Re: ABP-320705-24 Strategic Infrastructure Development - Proposed development of 9no windfarms in Co. Clare and in the townland of Court, Co. Limerick

**DIRECTOR GENERAL'S REPORT IN ACCORDANCE WITH THE
REQUIREMENTS OF SECTION 37E (4) OF THE PLANNING AND
DEVELOPMENT ACT 2000 (AS AMENDED) IN RELATION TO
KNOCKSHANVO WINDFARM**

ABP REFERENCE: PA03.320705

PROJECT: Knockshanvo Wind Farm Development

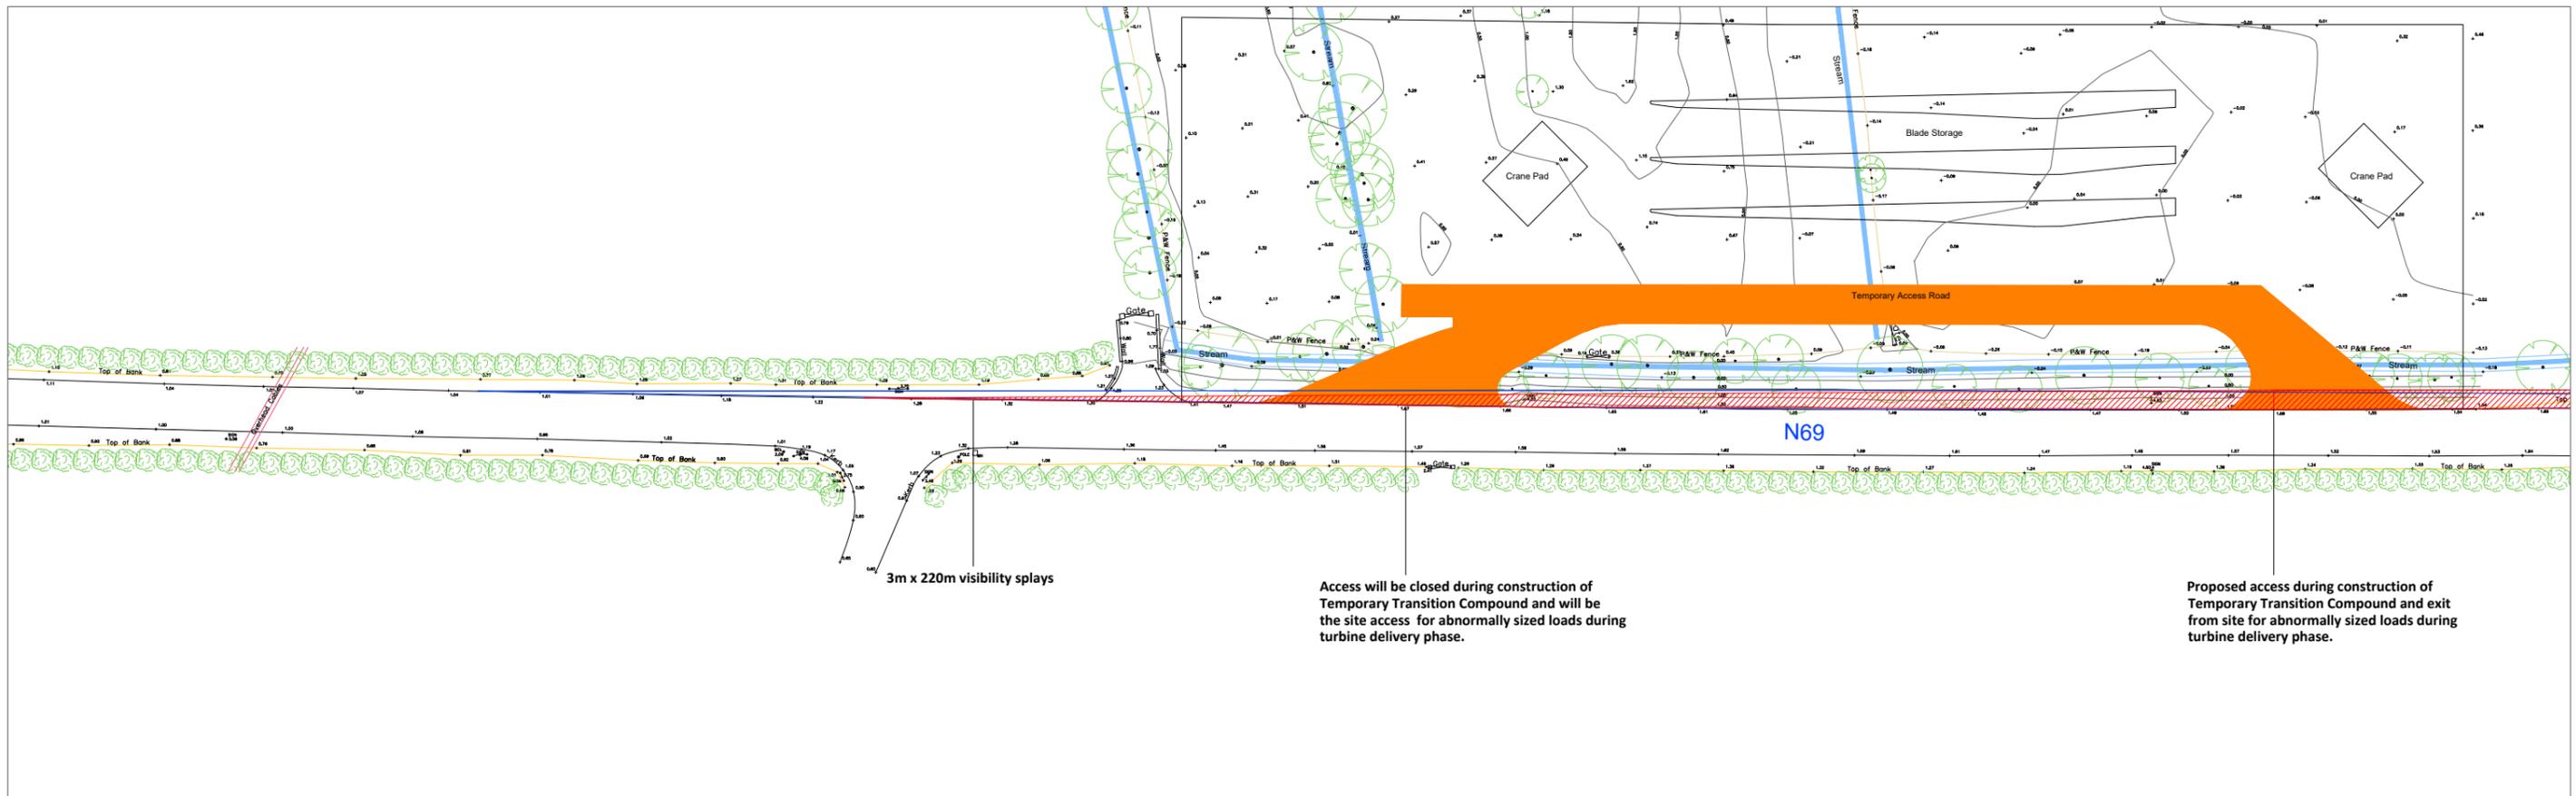
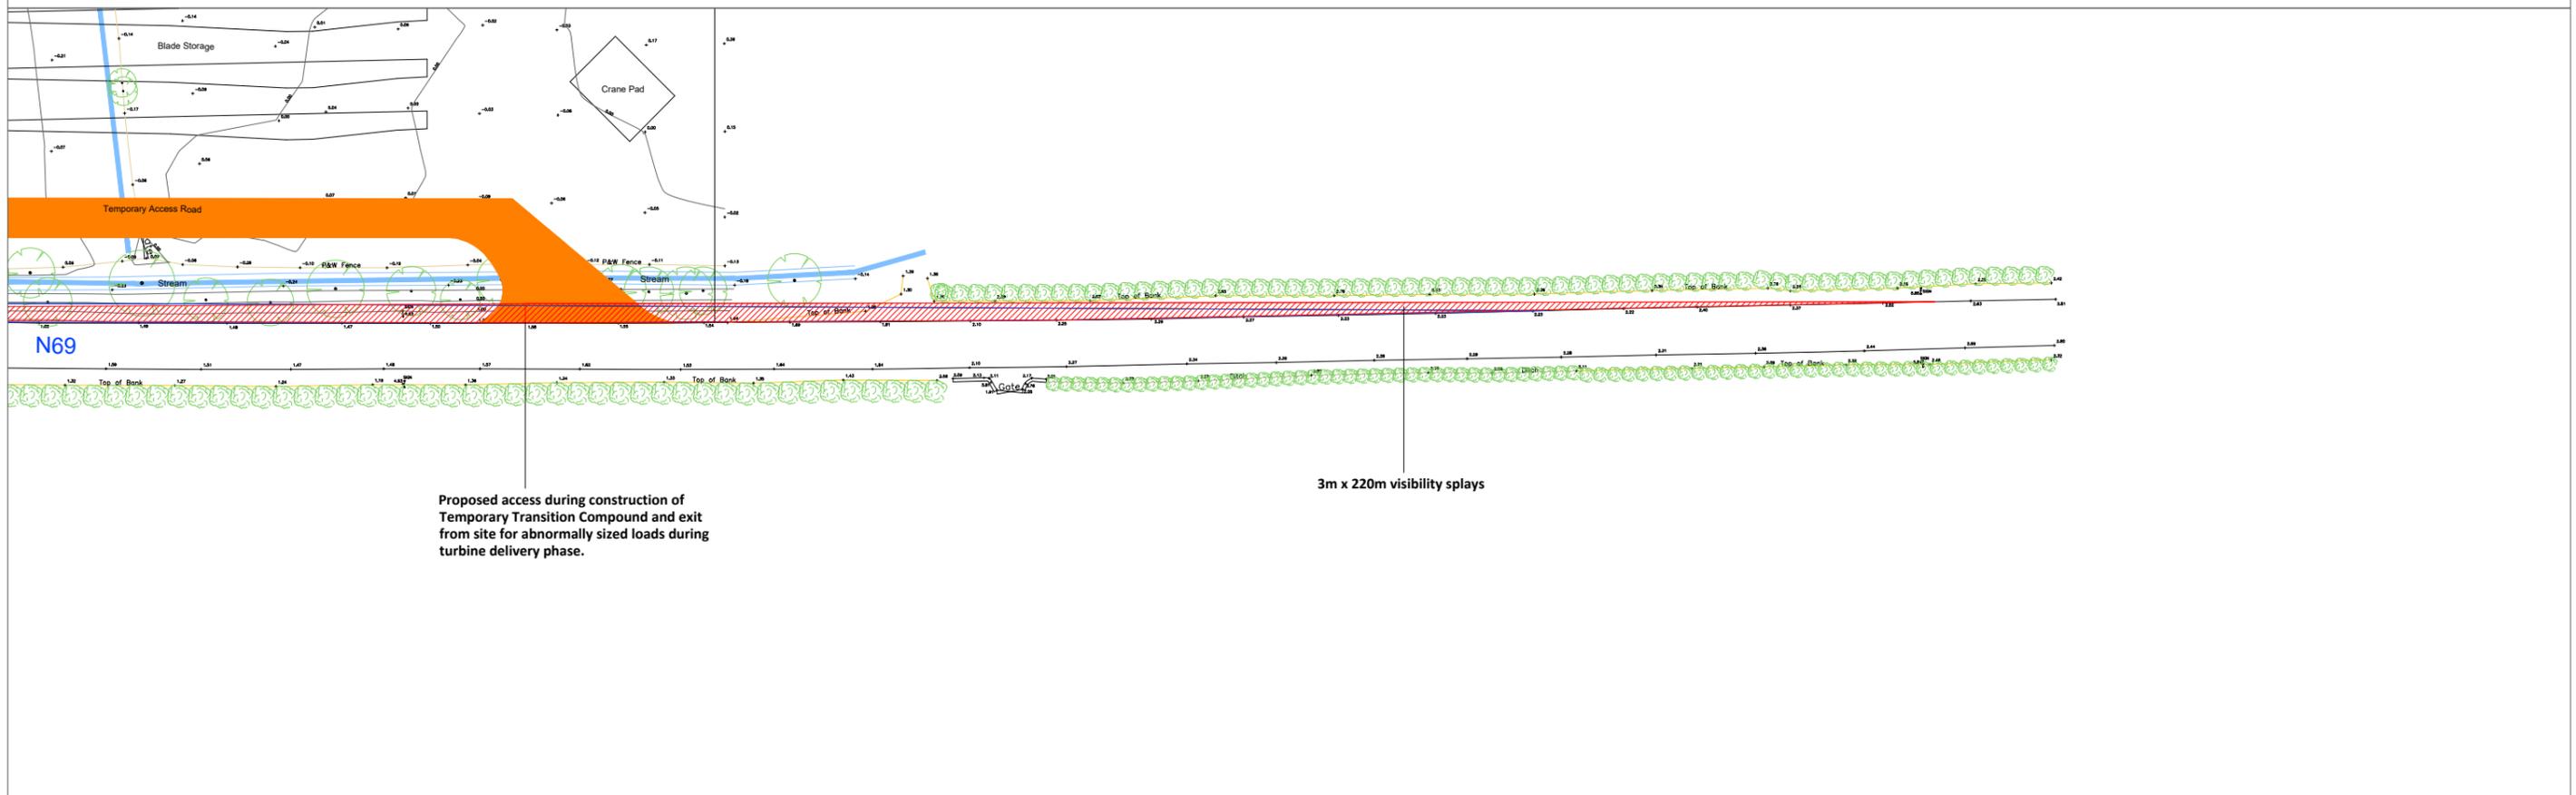
safety, current and future capacity and function of national roads. As set out below, the Roads Department do not consider the location suitable in the interest of safety. It is considered that the section of the N69 in question has a straight road alignment which would allow vehicles to approach the proposed entrance and egress at speed. It is noted that the vehicles in question, entering the site would be slow moving in contrast to the approaching vehicles. The proposed development is therefore not acceptable with regard to Policy TR O39.

- Roads Department (report dated 11/10/2024) are not in favour of the proposed development and are recommending refusal. They advise that the location is deemed not suitable in the interest of safety due to the speed of approaching vehicles on this stretch of road alignment. In addition, there is a private entrance adjacent to the proposed site and it is noted that the proposed vehicles entering the site would be slow moving in contract with the approaching vehicles. It is stated that the proposed development contains a new/intensified access onto national road in a 100kph zone and so is in conflict with the Spatial Planning and National Roads Guidelines for Planning Authorities. It is also in conflict with the Limerick Development Plan 2022 – 2028.
